Our Ref : Cochlear Response to Agency Submissions

COCHLEAR LTD RESPONSE TO AGENCY SUBMISSIONS

Thank you for your recent comments in relation to the proposed development of the new Cochlear facility at Macquarie University. Following receipt of additional comments from the Department of Planning, Ministry of Transport, Roads and Traffic Authority and Ryde Council, we are pleased to provide you with the following consolidated response.

Intersection Layout – Waterloo Road/Herring Road

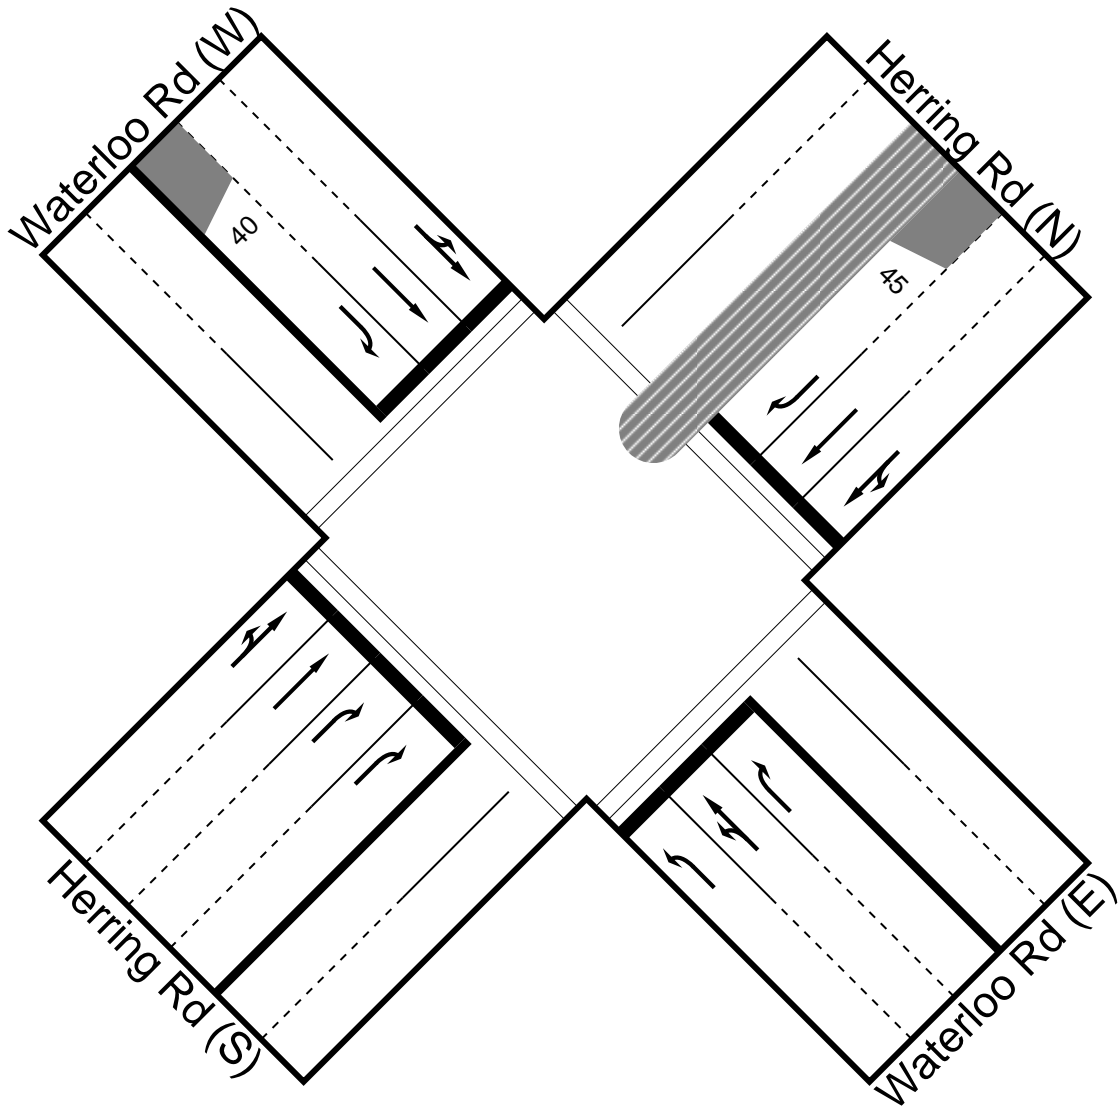
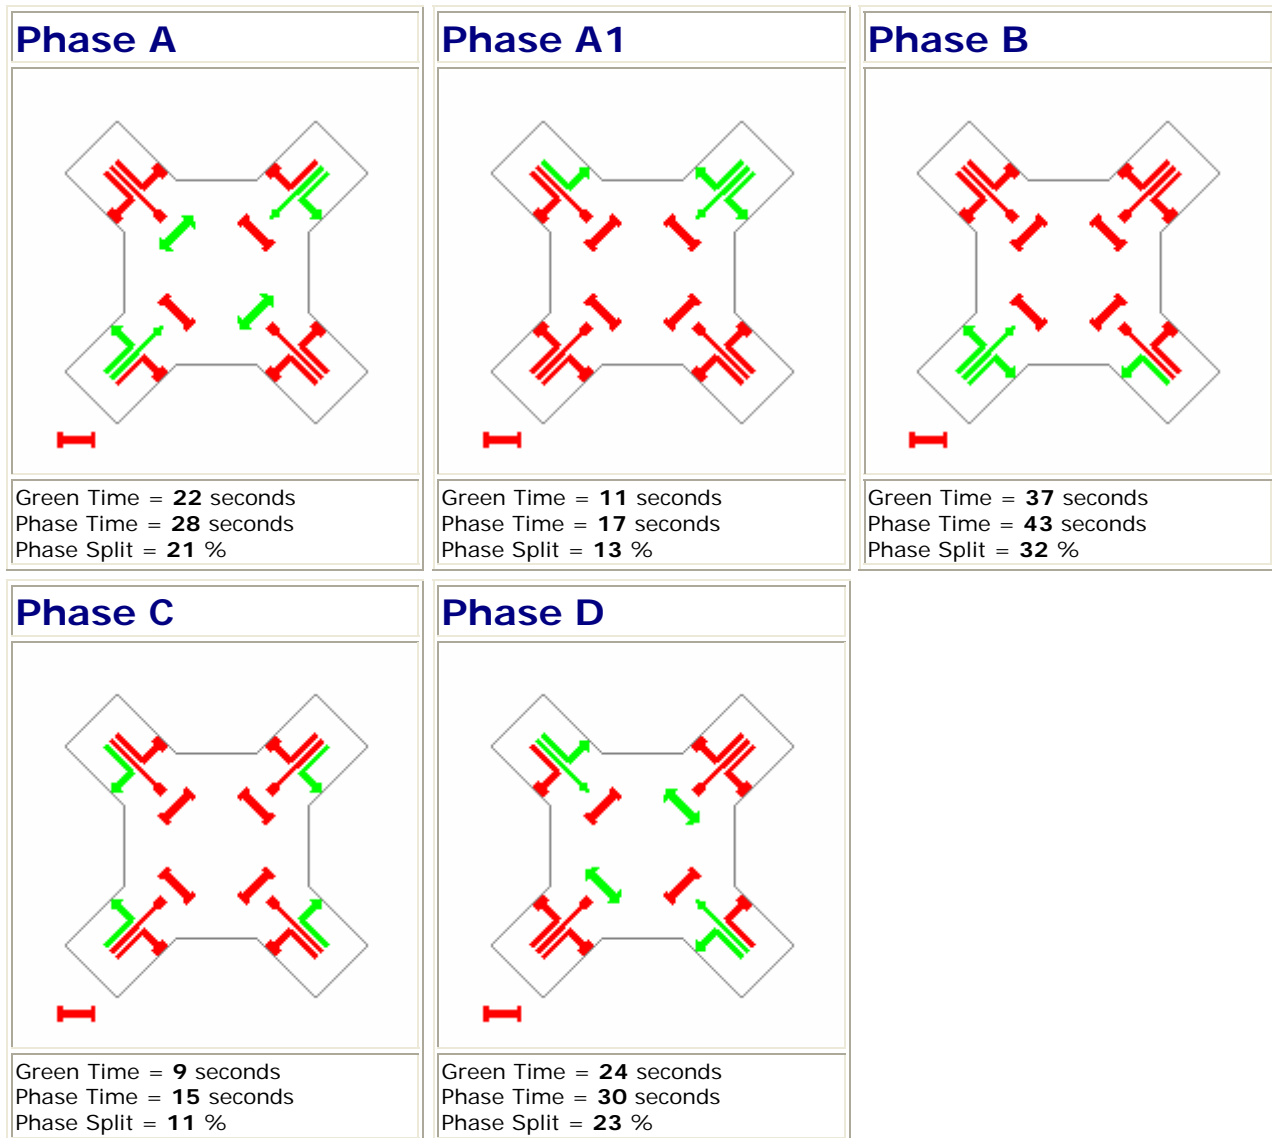
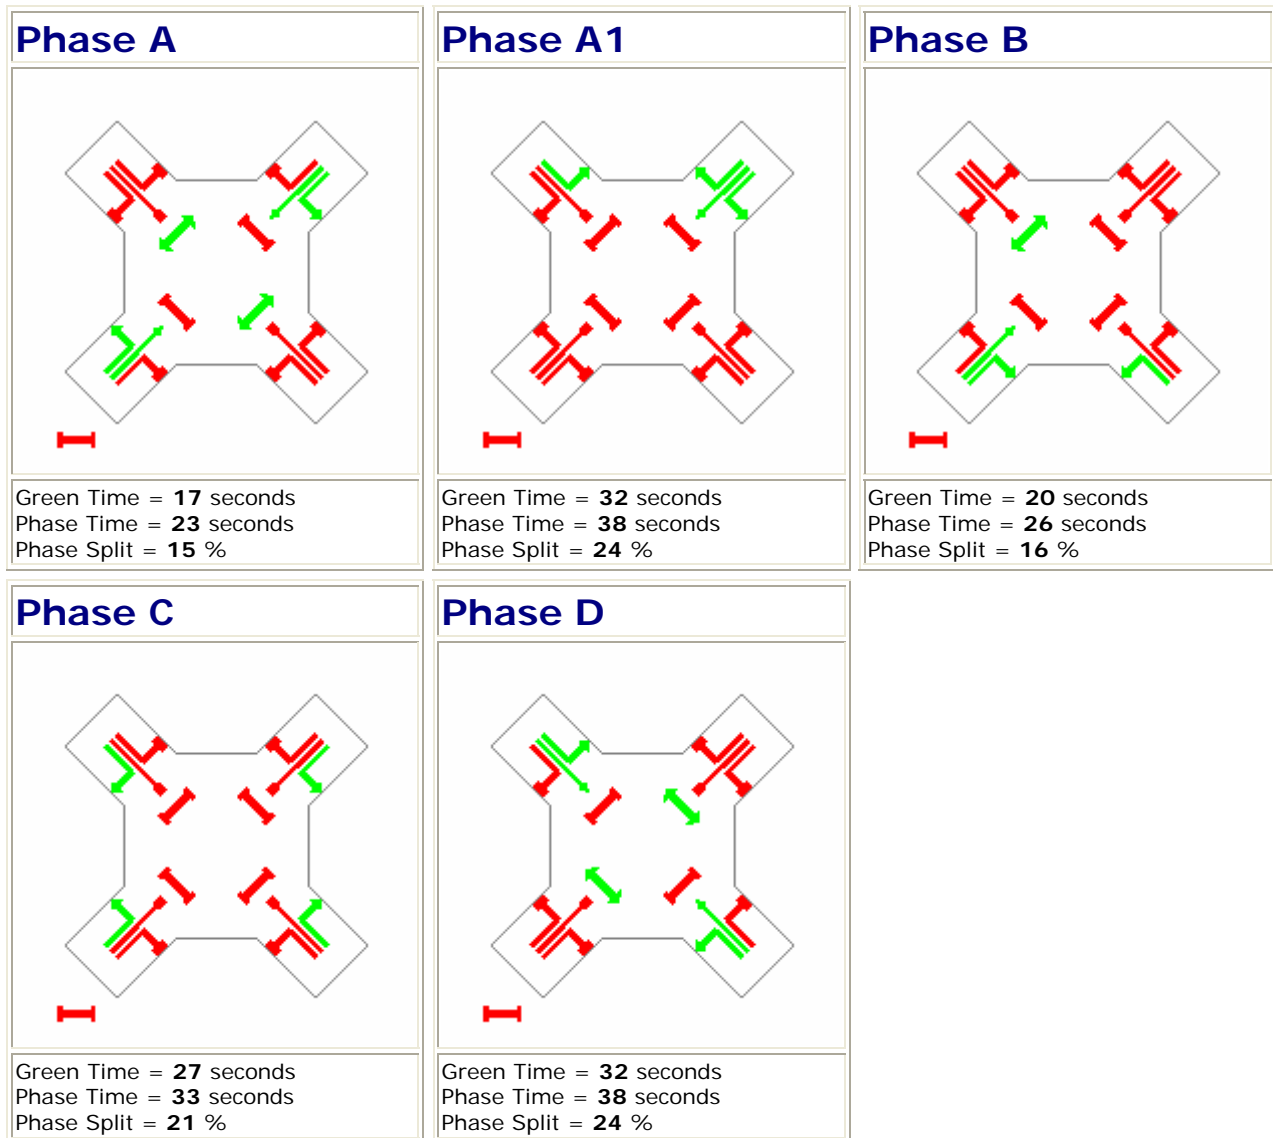
Waterloo Road/Herring Road:

- i) *Provide an additional short (55m) right turn lane in the Herring Road (north) leg;*
- ii) *Modify the Herring Road (north) leg to provide the following lane arrangement (LT/T/T/R) ;*

- iii) *Remove the kerbside parking (ie: Provide full time No Stopping) along Herring Road south of the Waterloo Road intersection (ie: southbound departure) for a distance of (minimum 150m) to ensure that three through southbound lanes are provided. (Note: The provision of full time No Stopping will be subject to the approval of Council's Local Traffic Committee);*

- iv) *Amend the Waterloo Road (east) leg to provide the following changes:*
 - a) *The westbound approach is amended from the existing (L/LT/R) to the following configuration of (L/L/T/R).*

- b) *The change in point (a) above will require the provision of an 80m long right turn bay. The provision of this bay can be accommodated by reducing the existing (eastbound) three lane departure along Waterloo Road from the signals at Waterloo Road/ Herring Road down to a localised two lane departure in the area of the proposed right turn bay.*

Macquarie University (MQ) has acknowledged that the proposed upgrade works at the intersection of Waterloo Road/Herring Road will be incorporated into the revised TMAP, currently being prepared for the Macquarie University Concept Plan (MUCP).

Macquarie University has undertaken to include the proposed works in the Memorandum of Understanding (MoU) for the MQ and City of Ryde (CoR) Voluntary Planning Agreement (VPA). Based on the MU correspondence we recommend that the proposed works are undertaken as part of the Universities commitments for the TMAP rather than Cochlear Stage 1 development.
